# Proposed SHD – Lands at Central Mental Hospital, Dundrum, Dublin 14

**Client: Land Development Agency**

**Stage 1 Road Safety Audit**

1	AUDIT INFORMATION	
1.1	Title	CMH DUNDRUM RSA1
1.2	Audit Reference Number	CMH DUNDRUM RSA1 MA 327
1.3	Project Code	CMHDUNDRUM
1.4	Date Audit Completed	21 <sup>st</sup> January 2022
1.5	Audit Attended By	Ludmila Santos
		Mark Andrews
1.6	Audit Team	
	Team Leader	Mark Andrews, ILTP
	Team Member	Ludmila Santos, ILTP

**DUNDRUM ROAD ACCESS JUNCTION (NORTH) - EXISTING ENTRANCE UPGRADED**  
 SCALE @ A1: 1:250  
 SCALE @ A3: 1:500

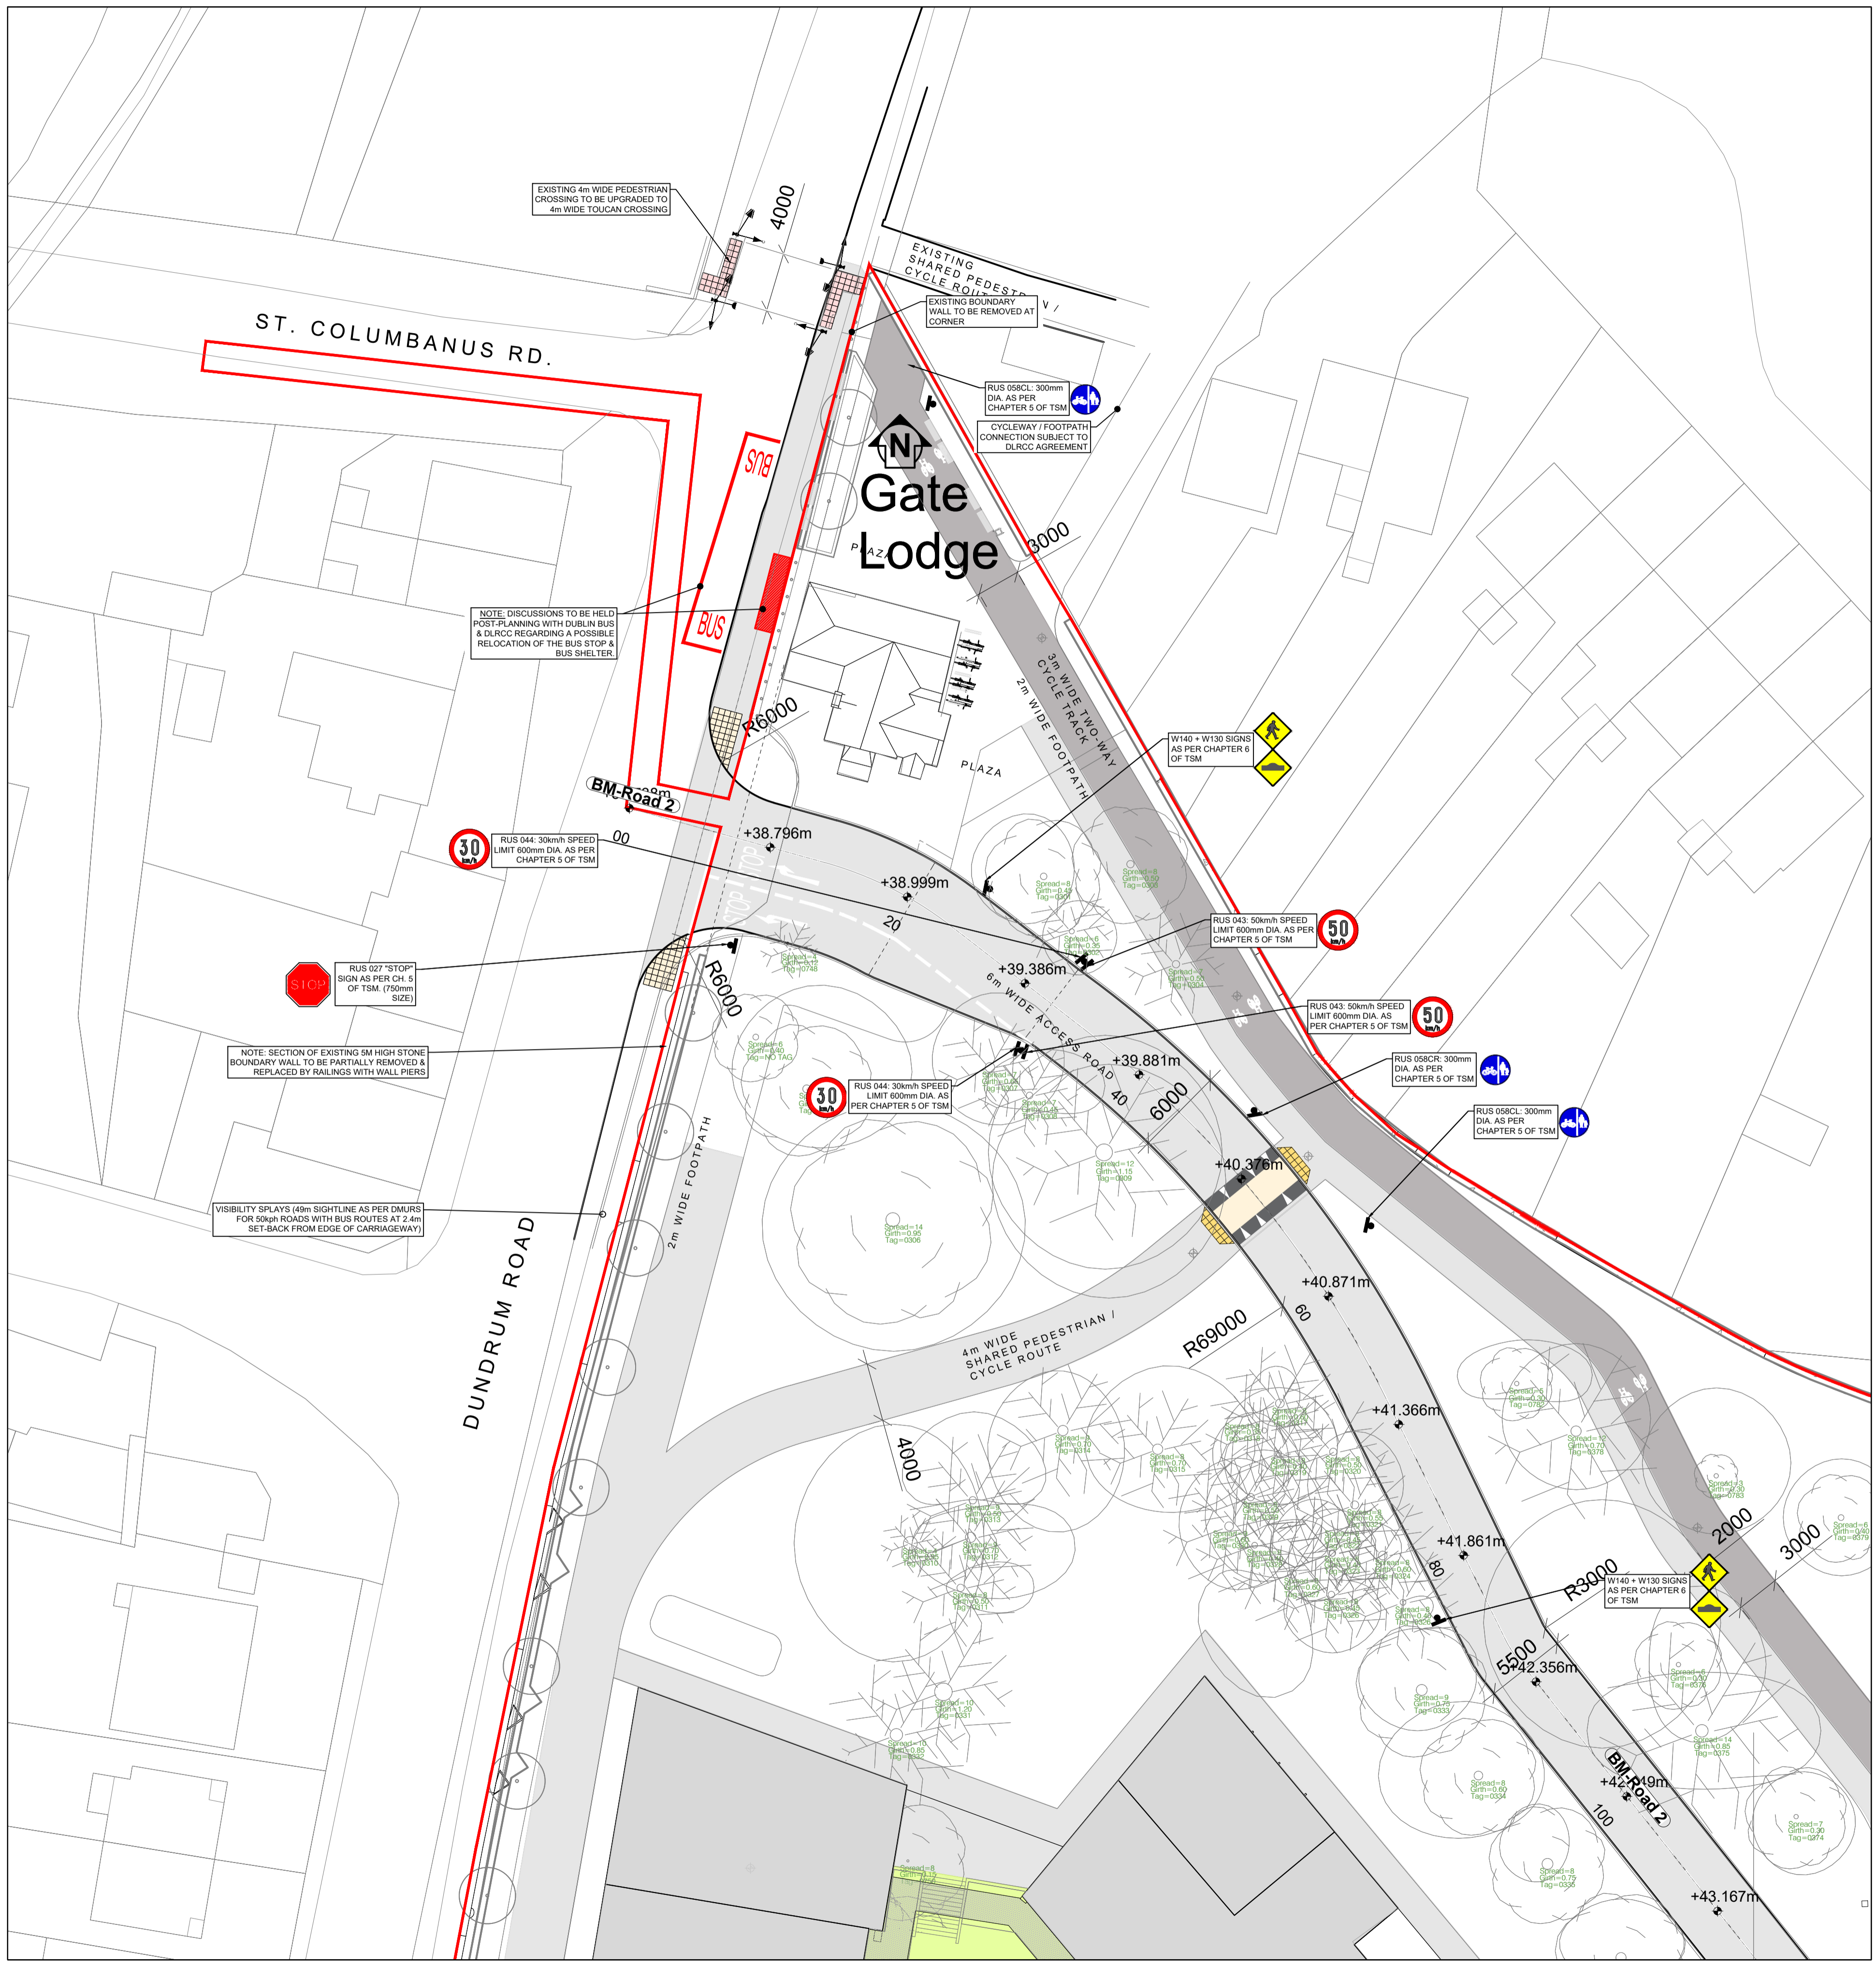
The information provided for audit shows that in order to improve visibility at the northern site access a bus stop is to be moved. However, the proposed location of the stop places directly in front of the signals for the pedestrian crossing at the junction of St. Columbanus Road. Without clear visibility to the signal heads vehicles following a stopping bus may attempt to pass and collide with pedestrians crossing the facility.

It is recommended that the design team relocate the bus stop to a location that does not impede visibility at the proposed access junction or the existing pedestrian crossing.

No further comments at this stage, although the recommendation remains.

Para No. in Report	Recommendation Accepted (Y/N)	Comments / Alternative Measures (Describe)	Alternative Measures Accepted by Auditor? (Y/N)
3.1	Y	The original bus stop relocation has now been omitted from the proposals. Bus stop location will be discussed and agreed with Dublin Bus and DLRCC.	Y

The information provided for audit shows that a row of proposed trees is to be planted between the two traffic access points to the site. These trees appear to be within the visibility requirements for vehicles emerging from the site. Should visibility be compromised by vegetation, landscaping or other roadside features and plant, traffic may emerge from the site into the path of conflicting vehicles resulting in T-bone type collisions.

It is recommended that the design team ensures that all visibility requirements are clear of landscaping, planting, and other roadside features.

3.2	Y	The design team will ensure that the appropriate visibility requirements are achieved.	Y
3.3	Y	Road levels to the centreline of roads have been provided. Detailed drainage proposals will be provided and drainage facilities will be located appropriately to drain surface water run-off.	Y

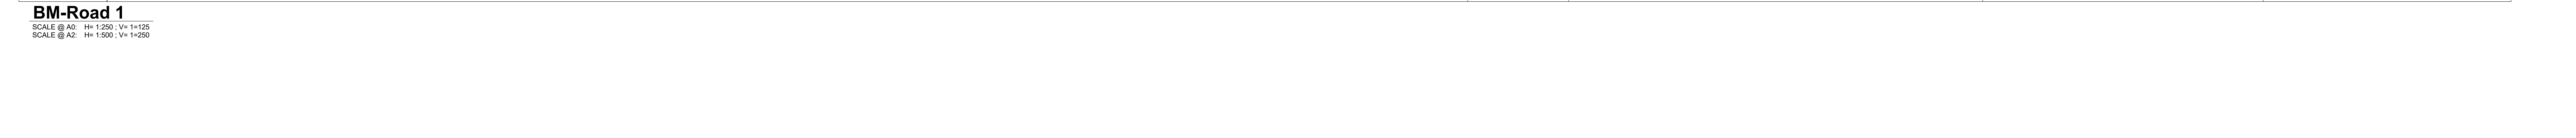
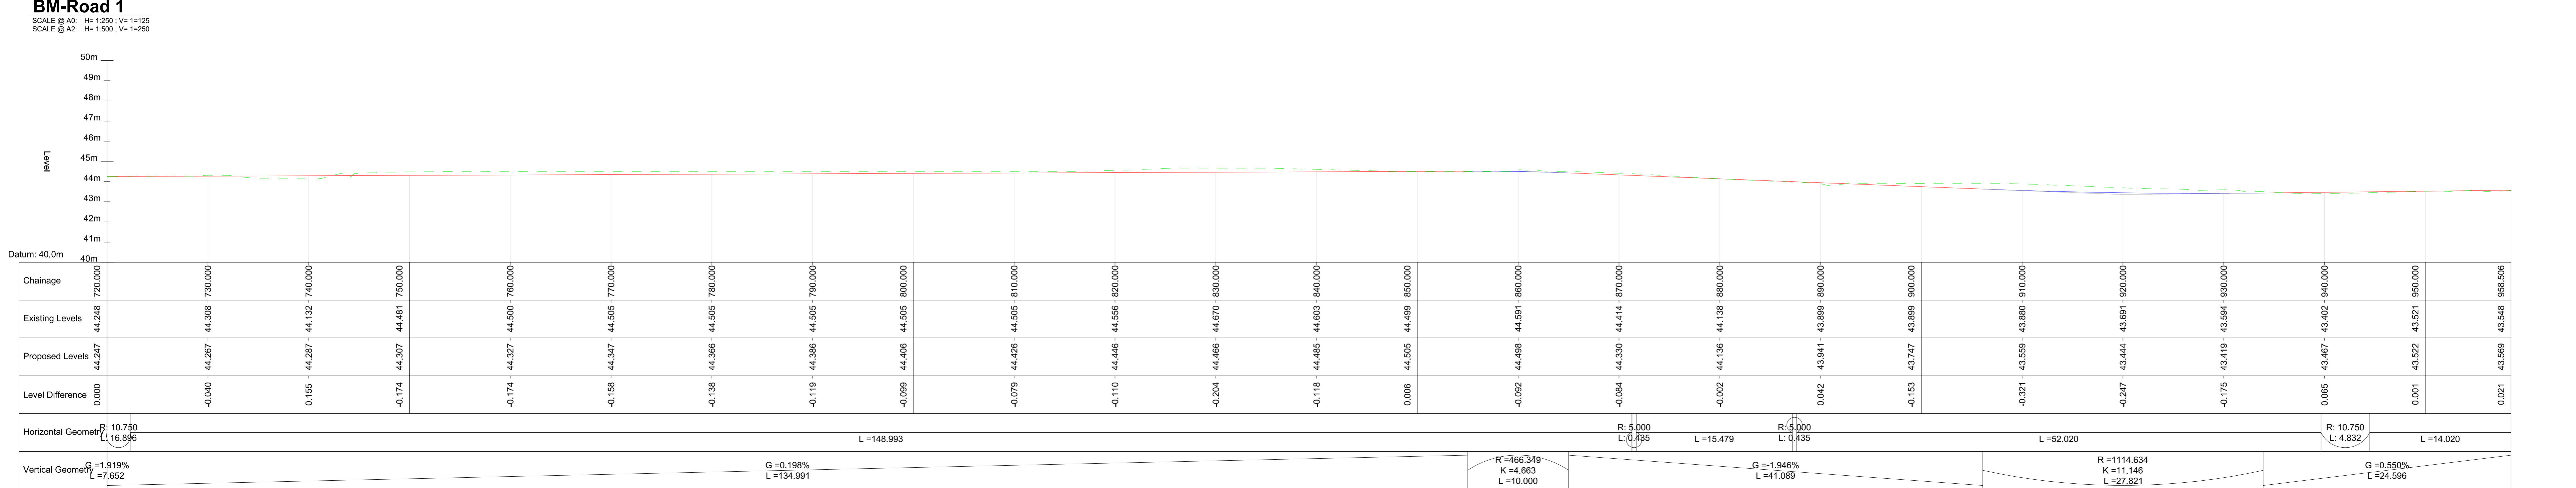
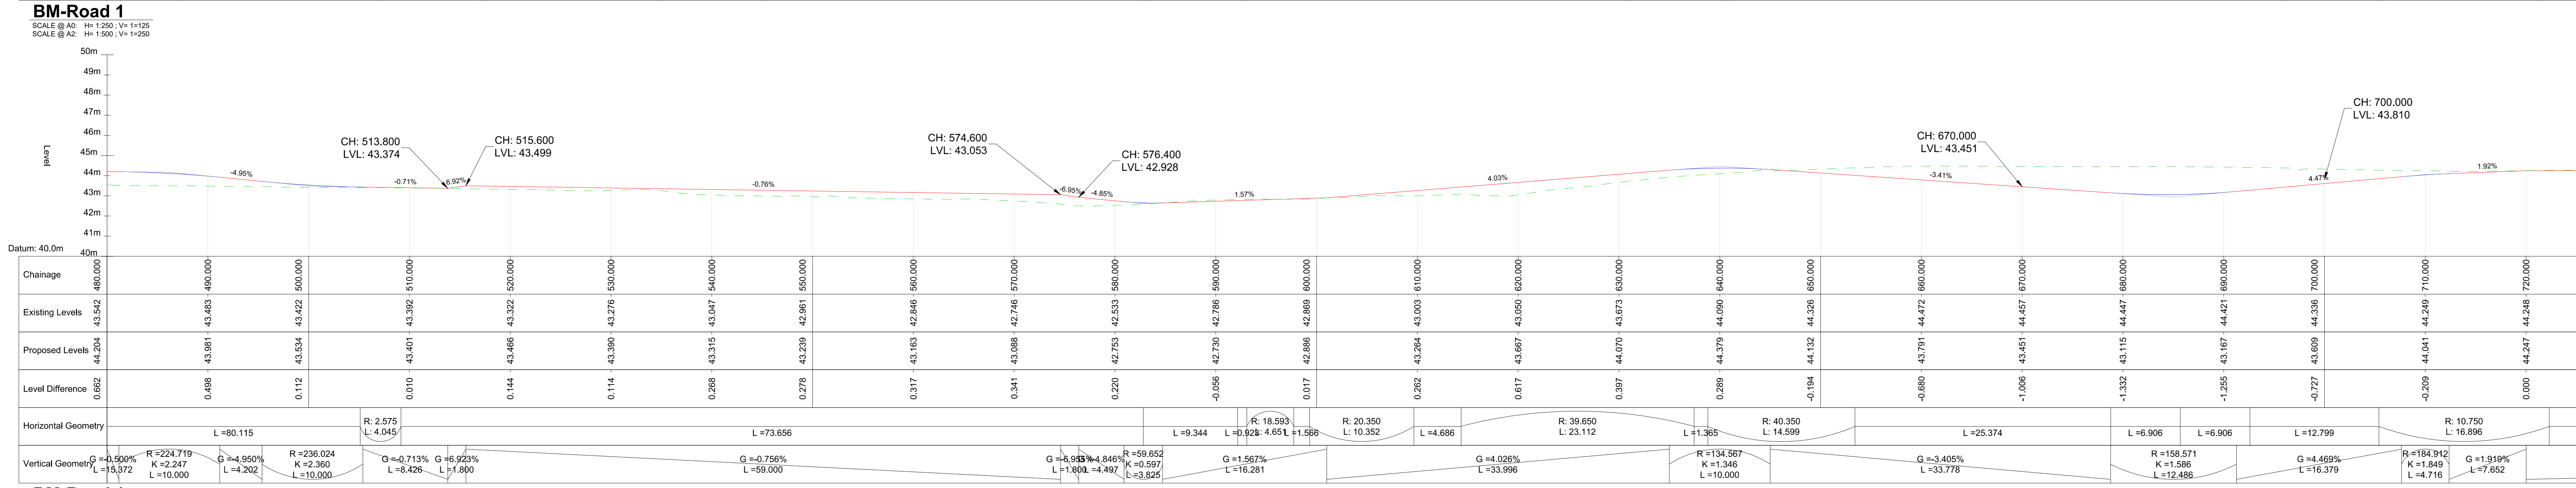
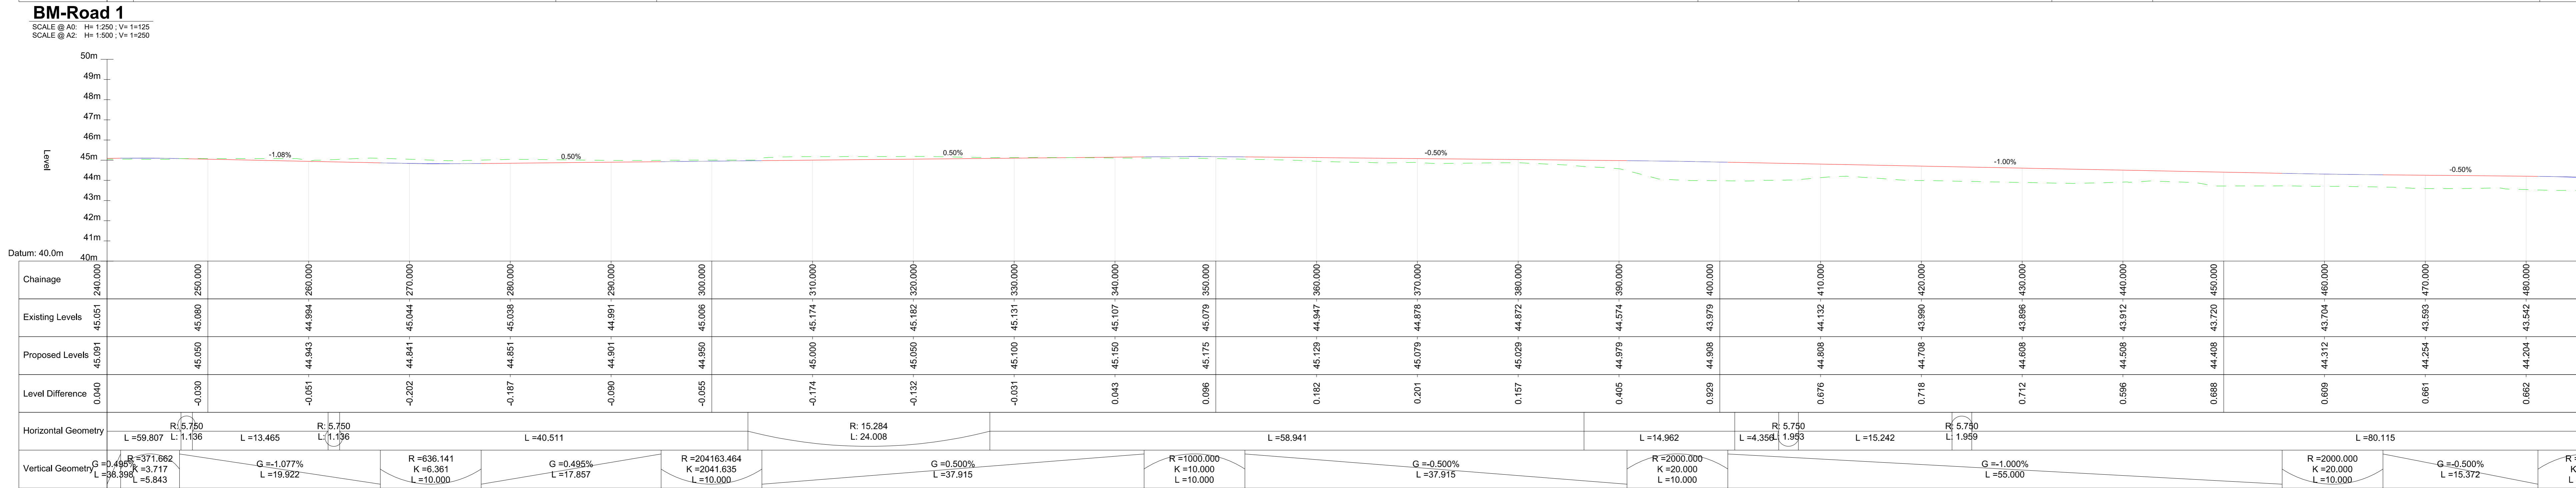
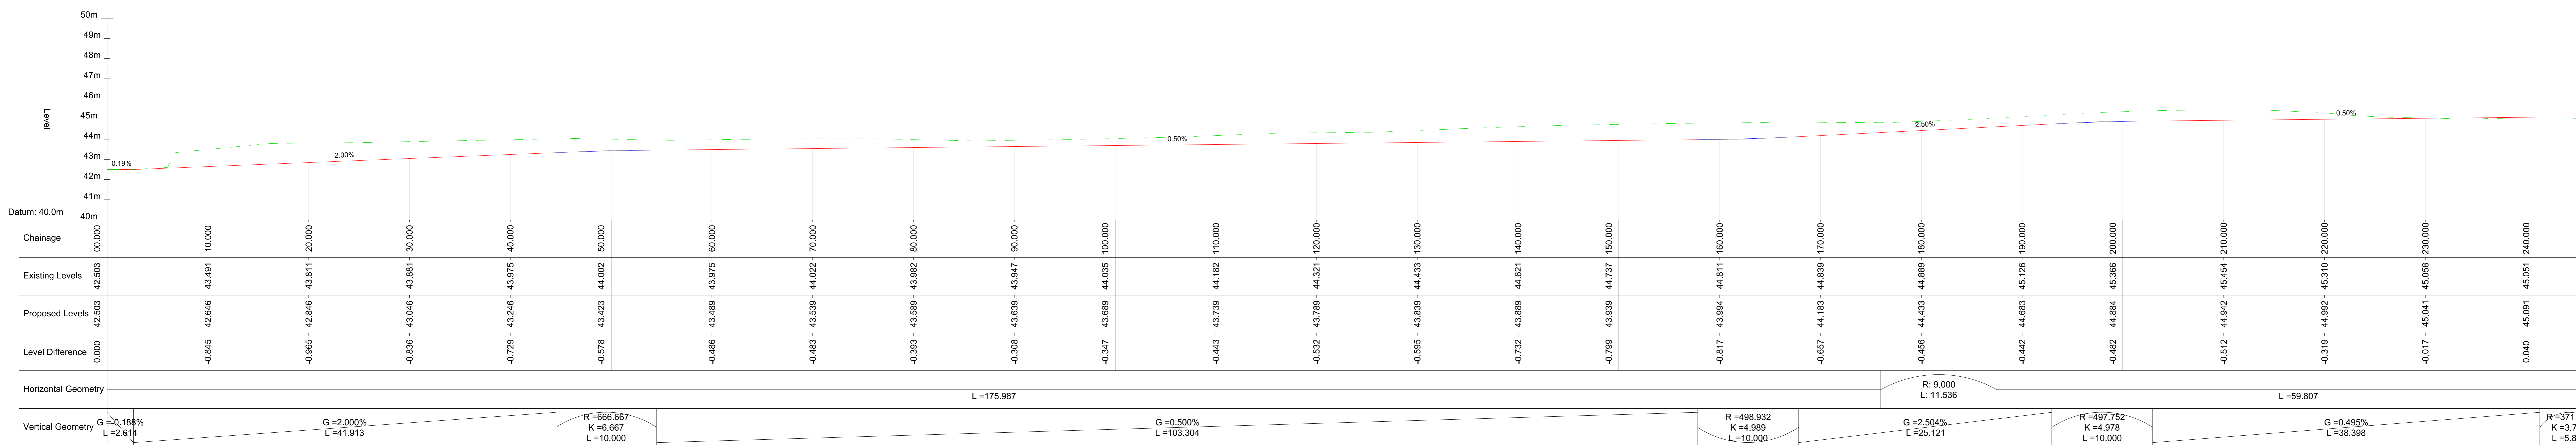
Details have been supplied of the location of drainage facilities and locations. However, level details have not been supplied to confirm these are located appropriately. The design team must ensure that the locations are located appropriately to drain the surface water.
